**WELWYN HATFIELD COUNCIL – DEVELOPMENT CONTROL**  
**DELEGATED REPORT**

<b>APPLICATION No:</b>	<b>S6/2007/1207/FP</b>
------------------------	------------------------

The application seeks full planning permission for the reconfiguration of the existing first floor accommodation which is currently contained wholly within the roofspace.

Project 57 The Ridgeway Cuffley  
 Drawing EXISTING Plans and Elevations  
 Date June 2007  
 Scale 1:50 1:100  
 Drawn DT 8529/S/001 a

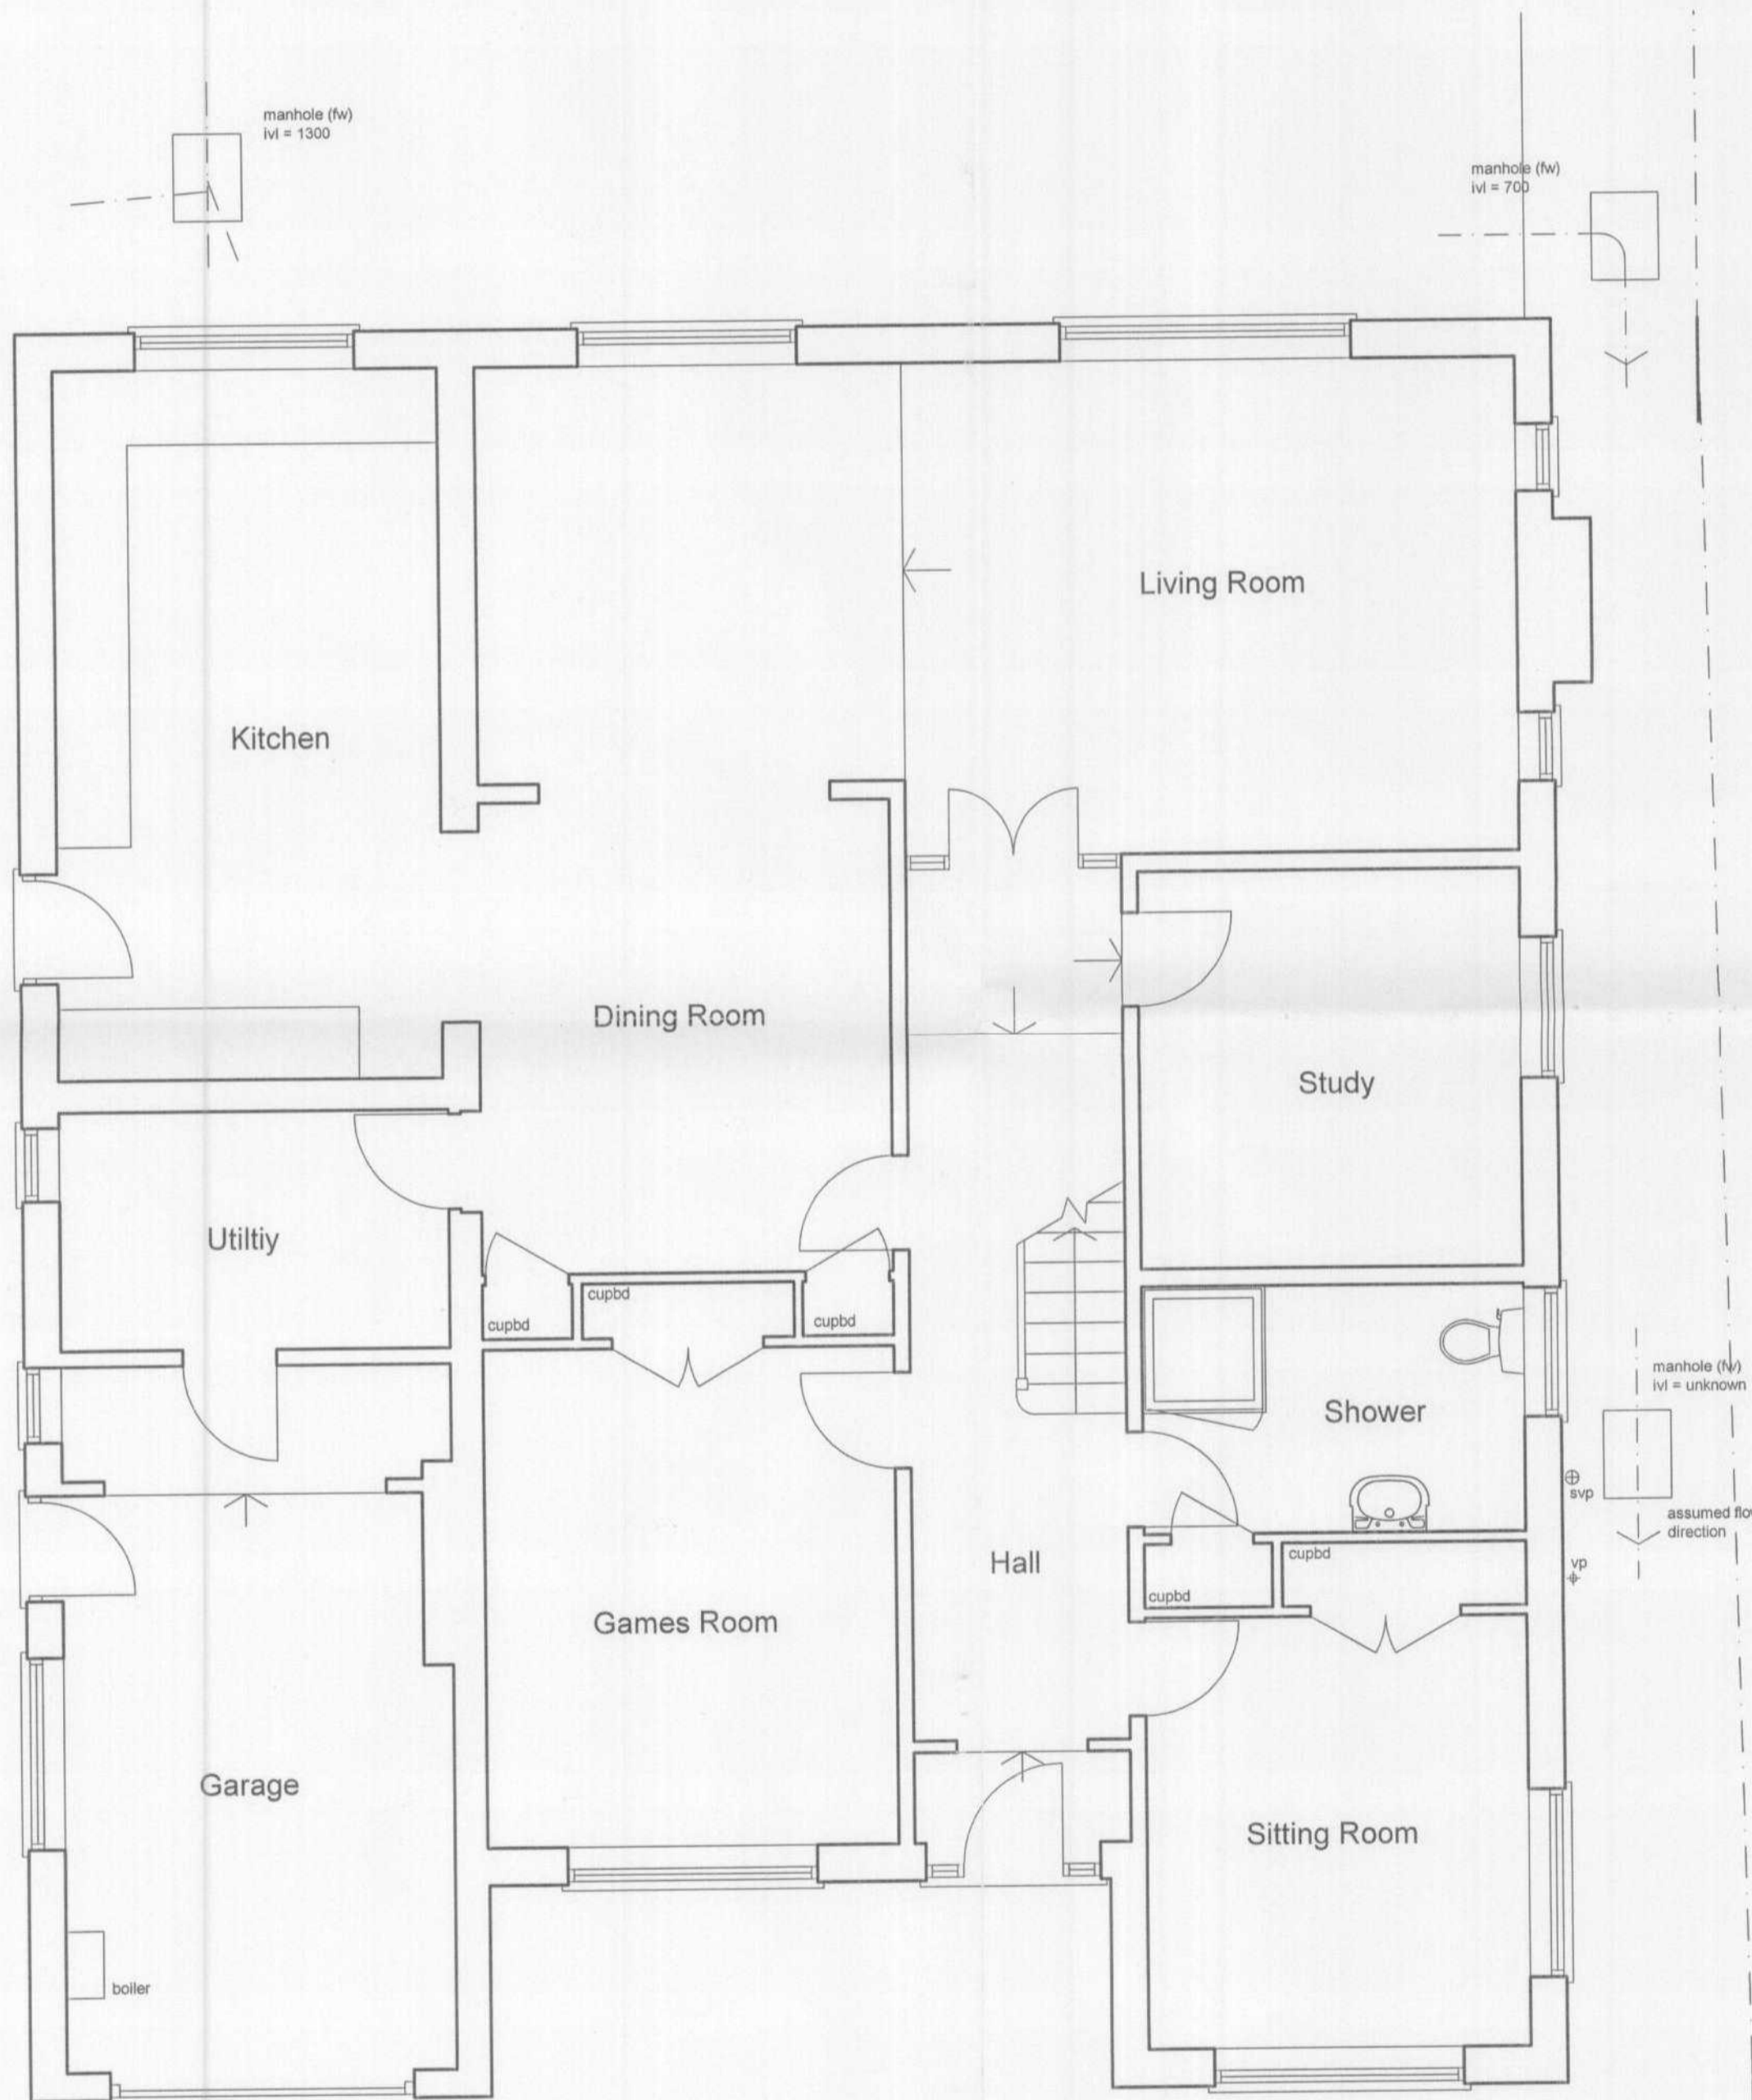
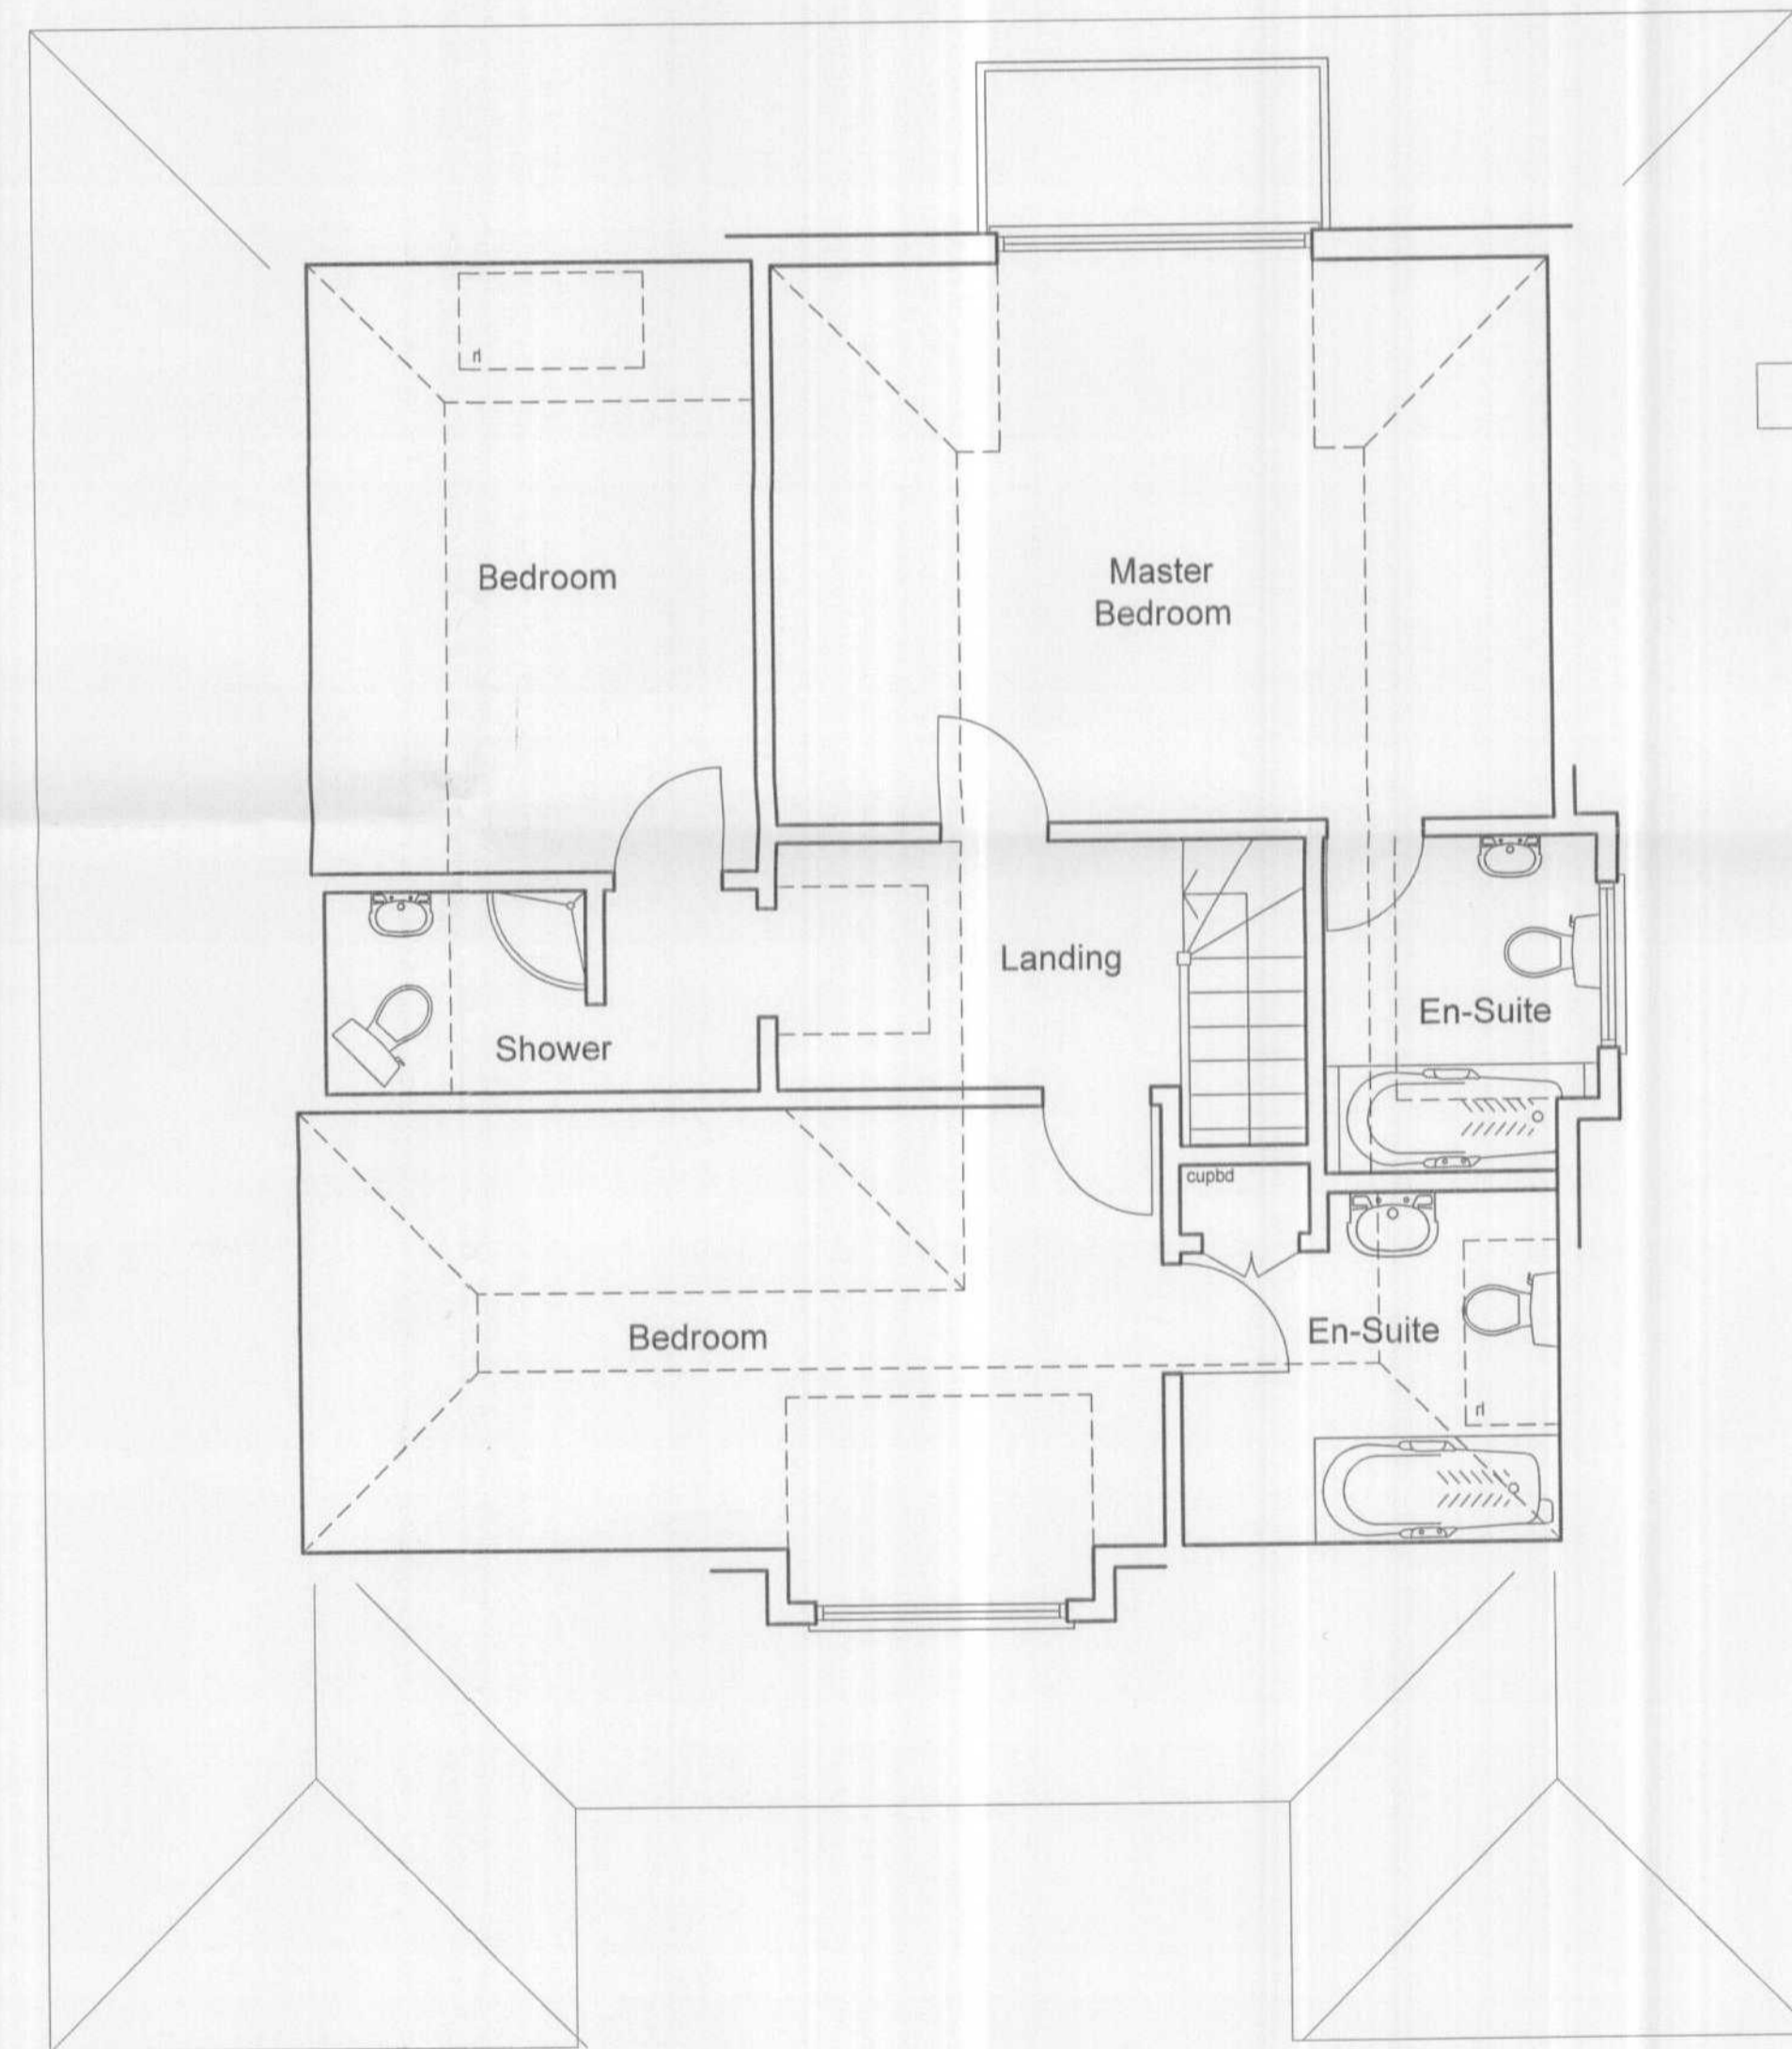
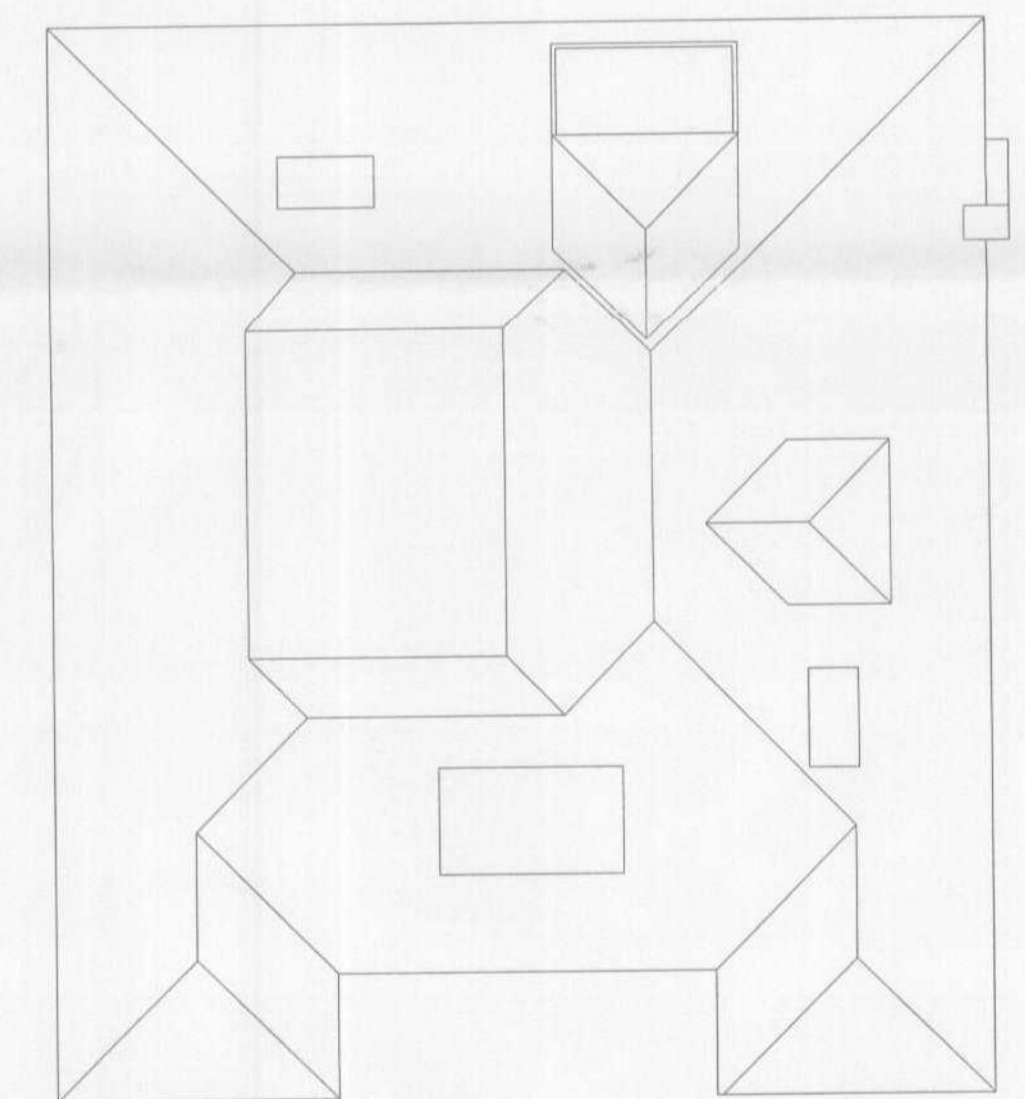
Policy D1 and D2 is relevant, along the Supplementary Design Guidance. The extent of the demolition is not entirely clear and the application is for extensions rather than a replacement dwelling. The applicant, however, confirmed on site that it is likely that the whole roof will need to be removed, and although this would be acceptable, it will be necessary to ensure that sufficient ground floor structure remains intact so that the character of the original building is retained. A planning condition to clarify the extent of the demolition would therefore be reasonable.

5. Prior to the commencement of works, drawings showing the extent of demolition are to be submitted to the Local Planning Authority and are to be agreed in writing. The development shall then be implemented in accordance with the agreed details.
